**ANGEL PLACE
LEVEL 8, 123 PITT STREET
SYDNEY NSW 2000**

02 February 2021

KAMBALA SCHOOL SSD 10385 – VIA ADDENDUM

5 SPORTS BLDG - NORTH ELEVATION - (section through drainage)
1:200

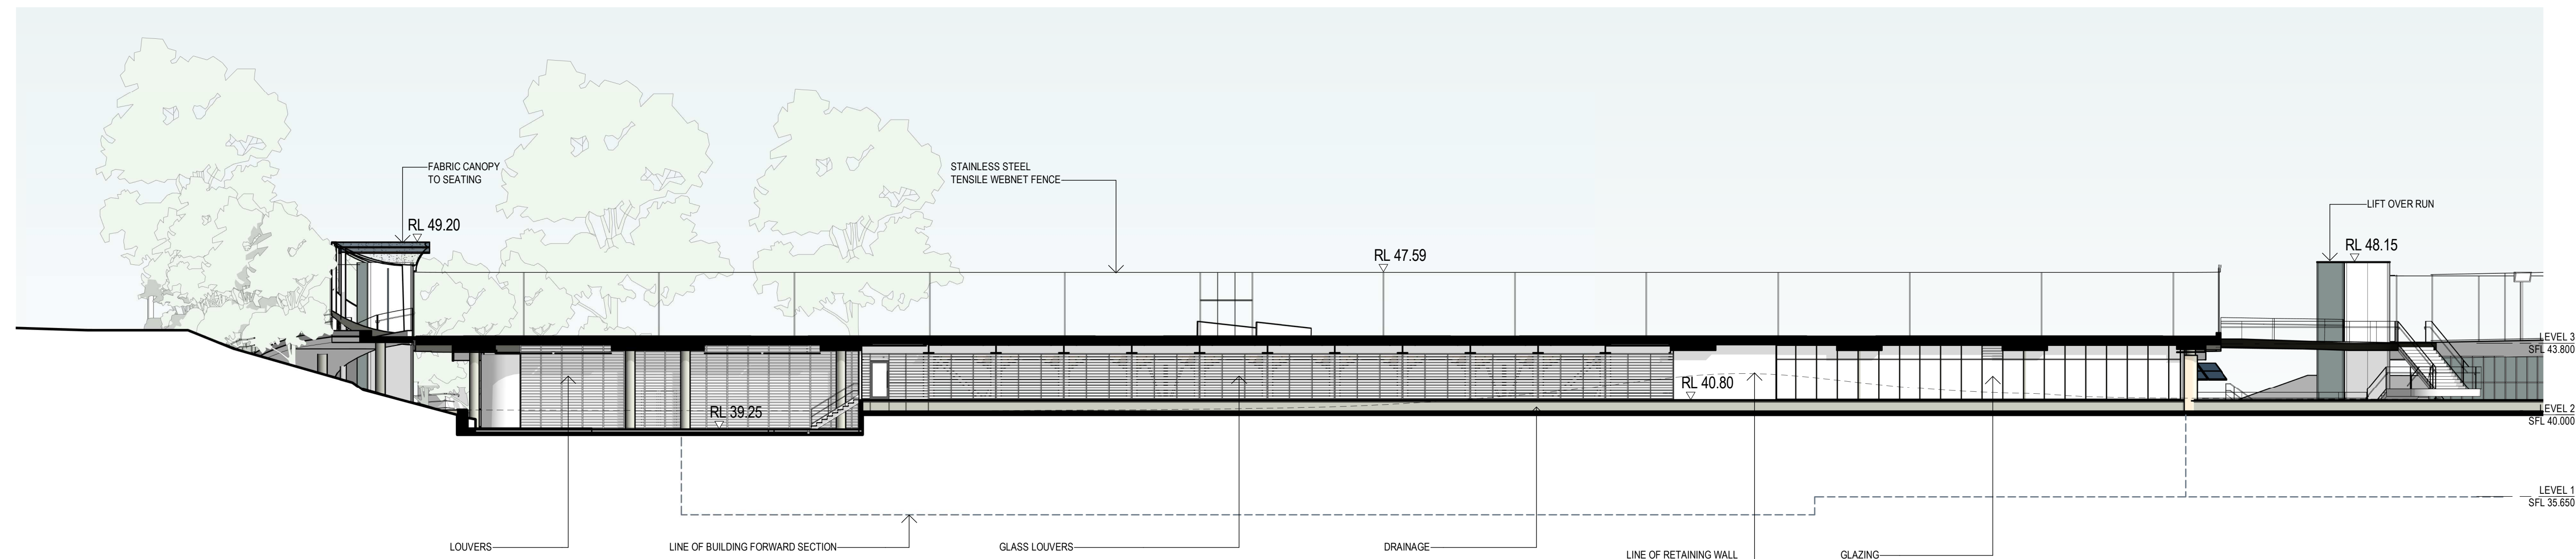
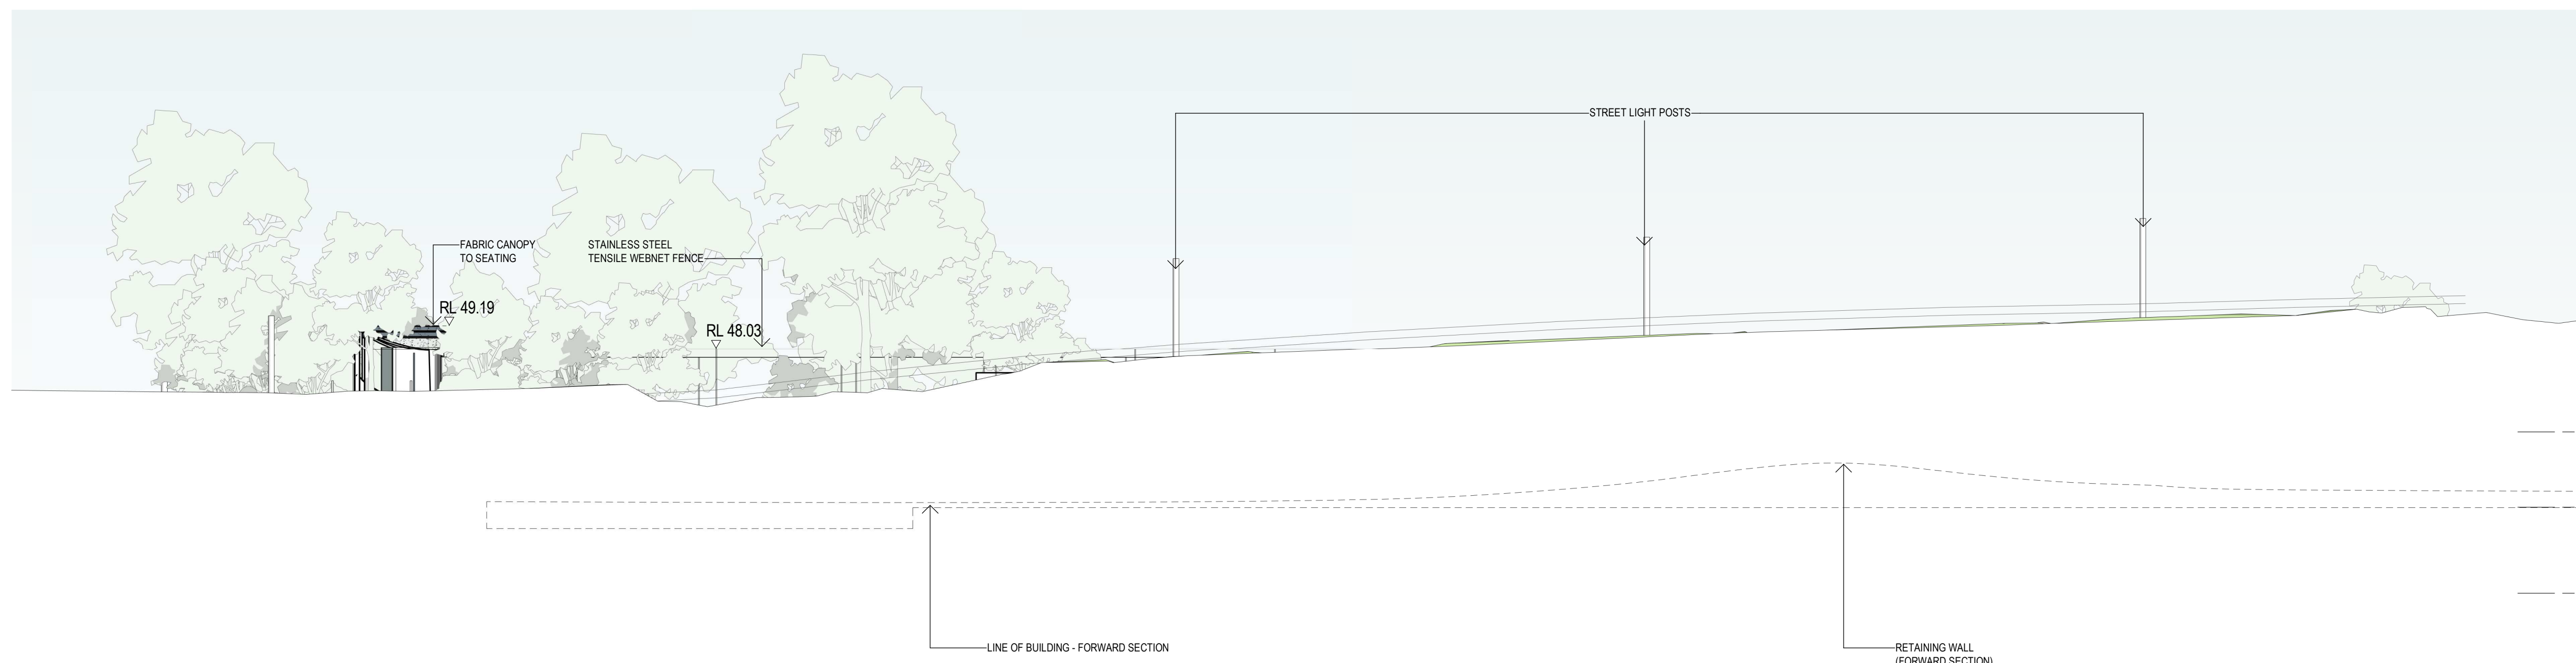
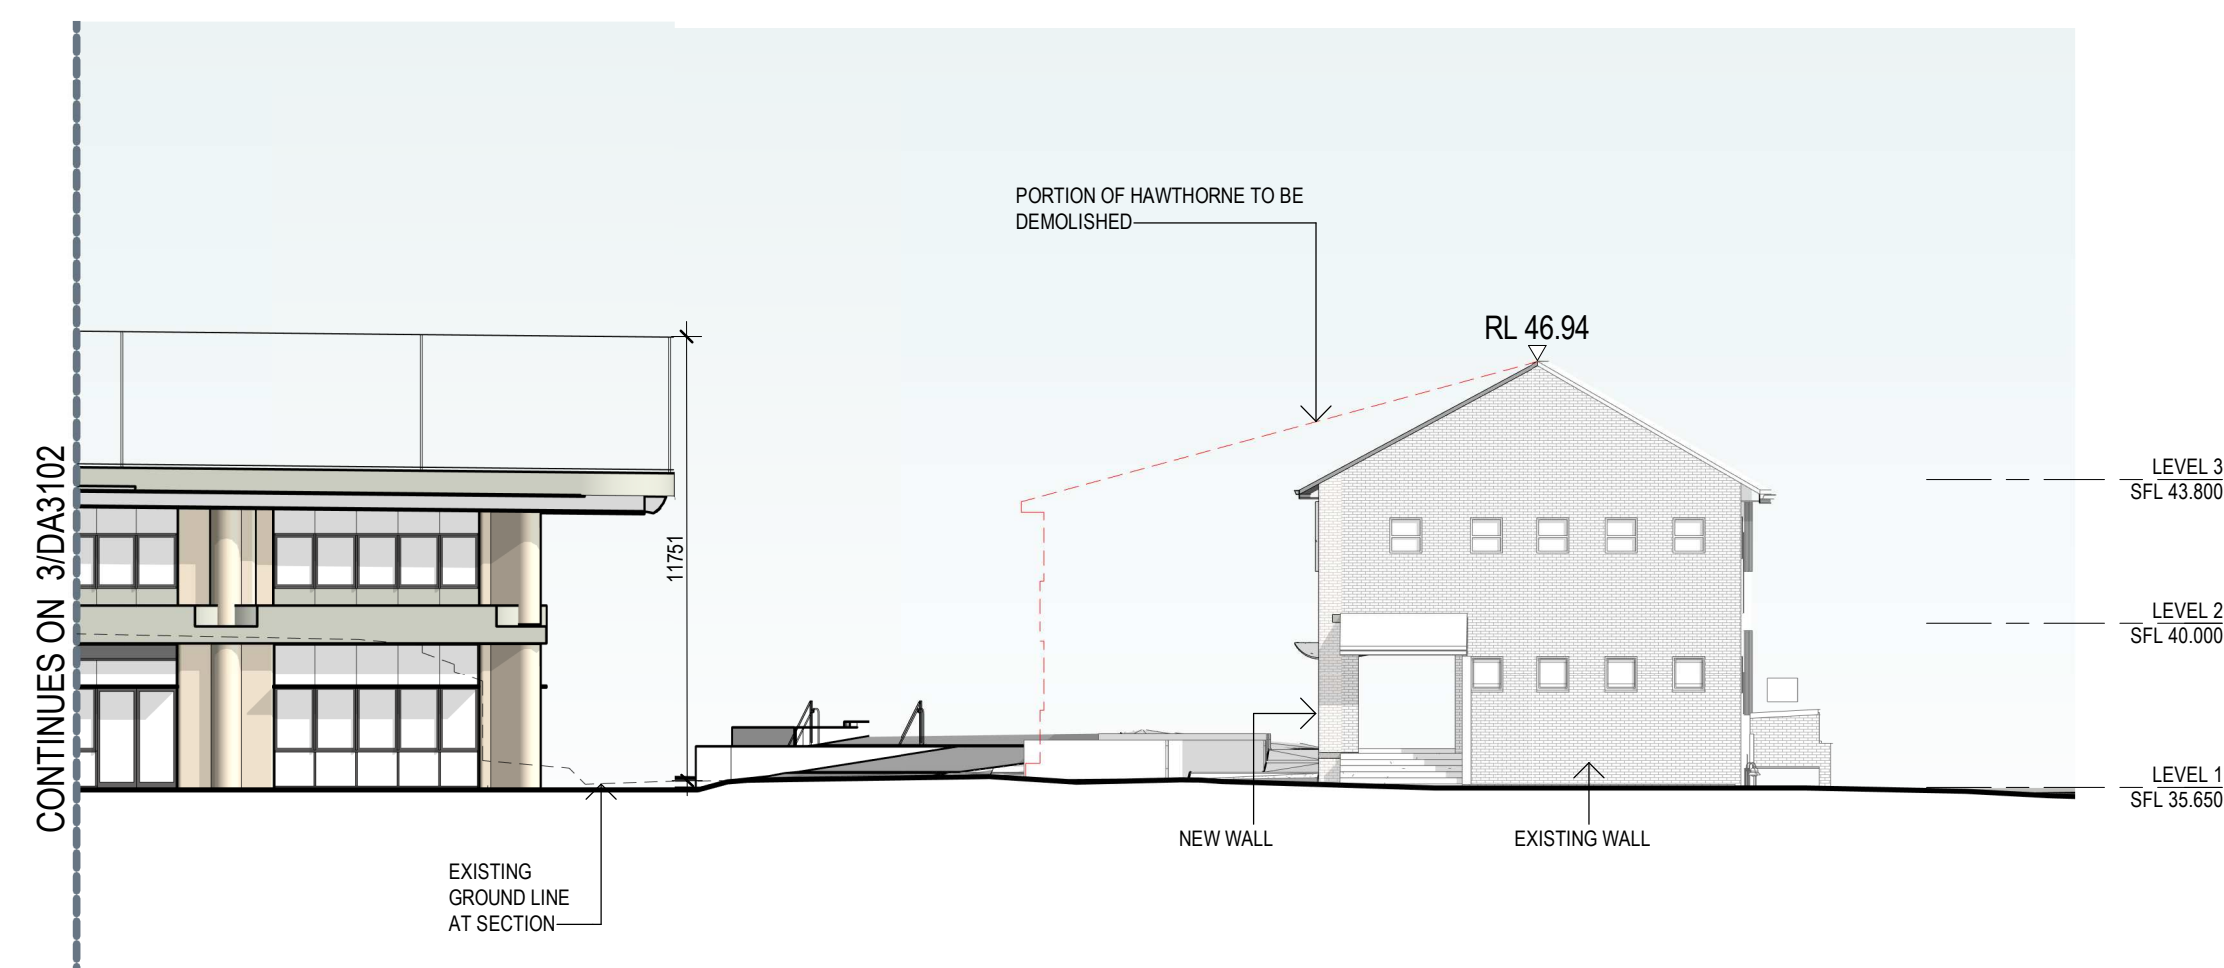
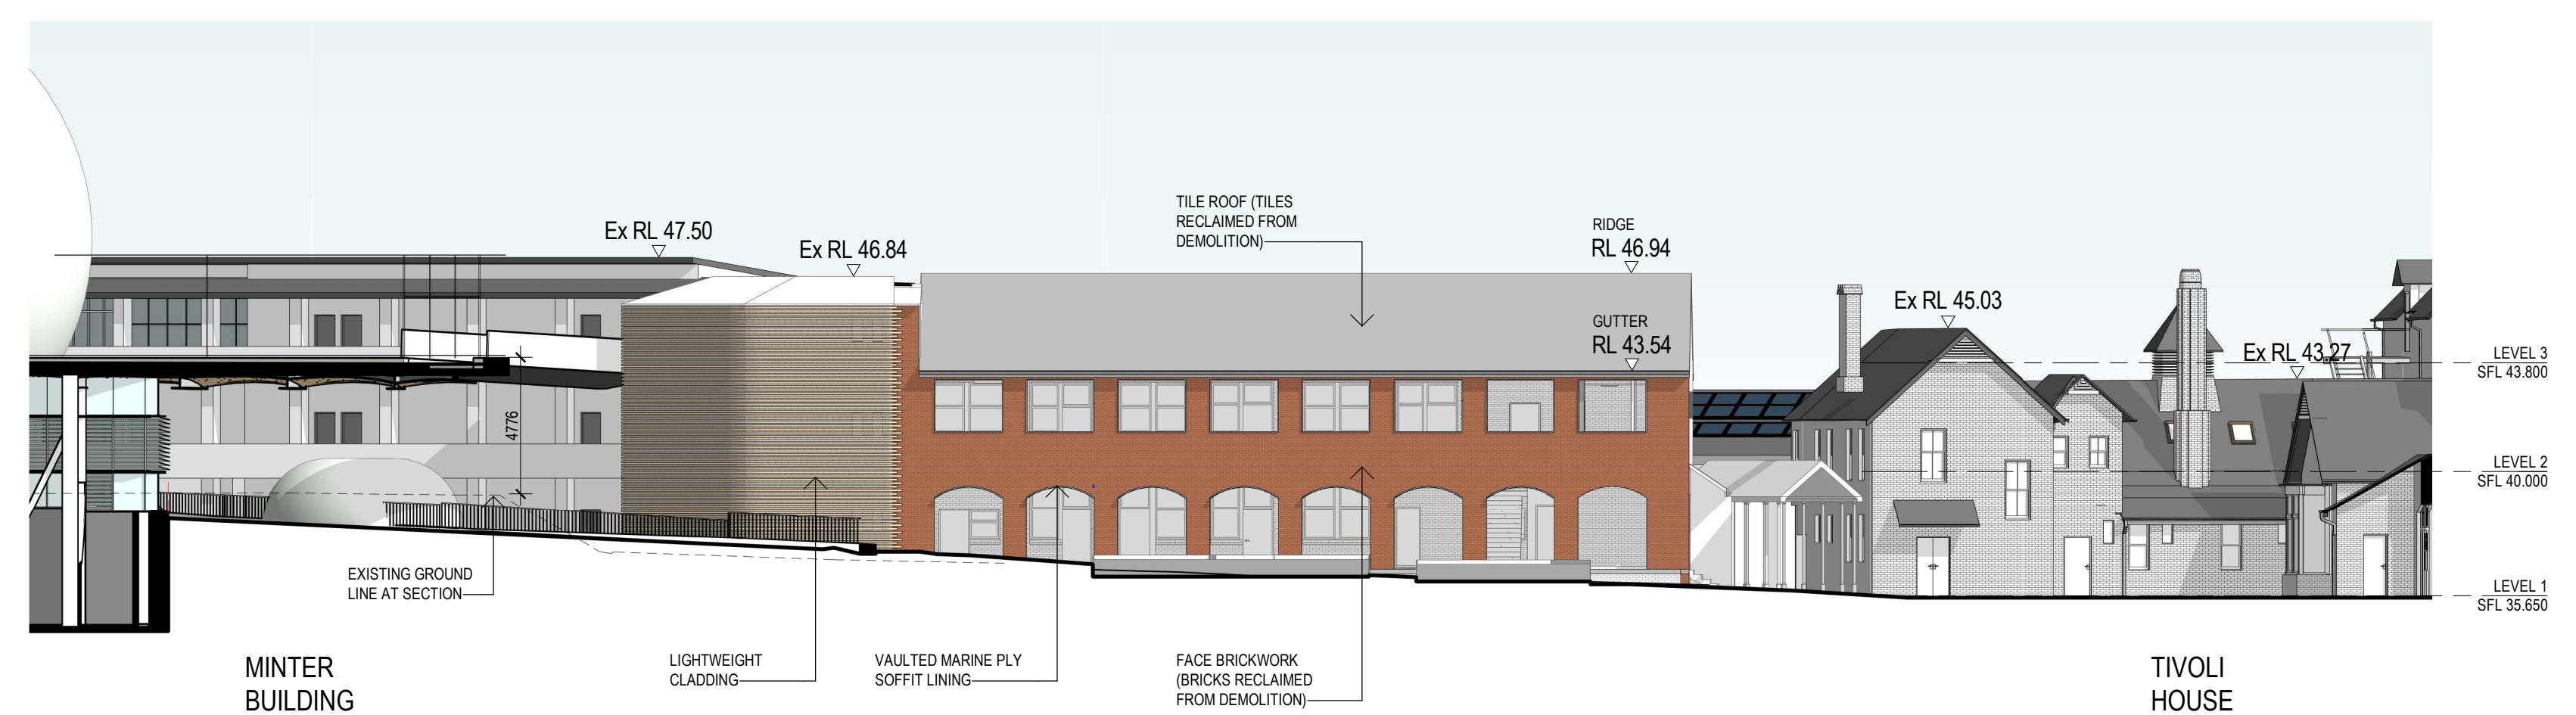
Under the Woollahra LEP 2014, the maximum permissible height on the subject site is 9.5 metres. According to the Cl. 4.6 report prepared by Ethos Urban, the proposal seeks a maximum height of 12.5 metres, three (3) metres higher than the LEP height limit.

The height non-compliance would result in unacceptable visual impacts on the existing public domain views as discussed previously. A proposal which complies with the height control would maintain higher visibility to the precinct's heritage building/site and would result in less impacts on the quality of the existing views.

All parts of the music building as shown in east and south elevations sit below or significantly below the height plane of 9.5m above natural ground. The north elevation shows that a minor amount of semi-translucent sports fencing and the upper part of two fence poles will sit above the LEP height control. The west elevation shows that the sports field surface structure, fencing and light poles sit above the height control. We comment that the solid and potentially most visible part of the built form proposed being the playing surface structure is a low horizontal form which sits well below the height of the New South Head Road carriageway, broadly at the height of the control. This form, the fencing structures and light poles will generate low levels of visual effects and minor visual impacts in downward views where they may be visible.

All parts of the sports building as shown in the north and west elevations sit significantly below the LEP height control except for a part fence panel and one (western-most) fence post which in our opinion generate negligible visual effects and minor visual impacts. The sports building south elevation shows that a short vertical section of a glass clad lift at the east end of the music building, will sit above the LEP height control. In addition a narrow horizontal section of sports fencing at the west end of the sports building including fencing material and fence posts will sit partially above the height control line. The form, height and materiality of the structures of the fencing structure and panels, light

poles and single vertical section of glass lift that will sit above the height control will not generate any significant visual effects or impacts on public domain views.
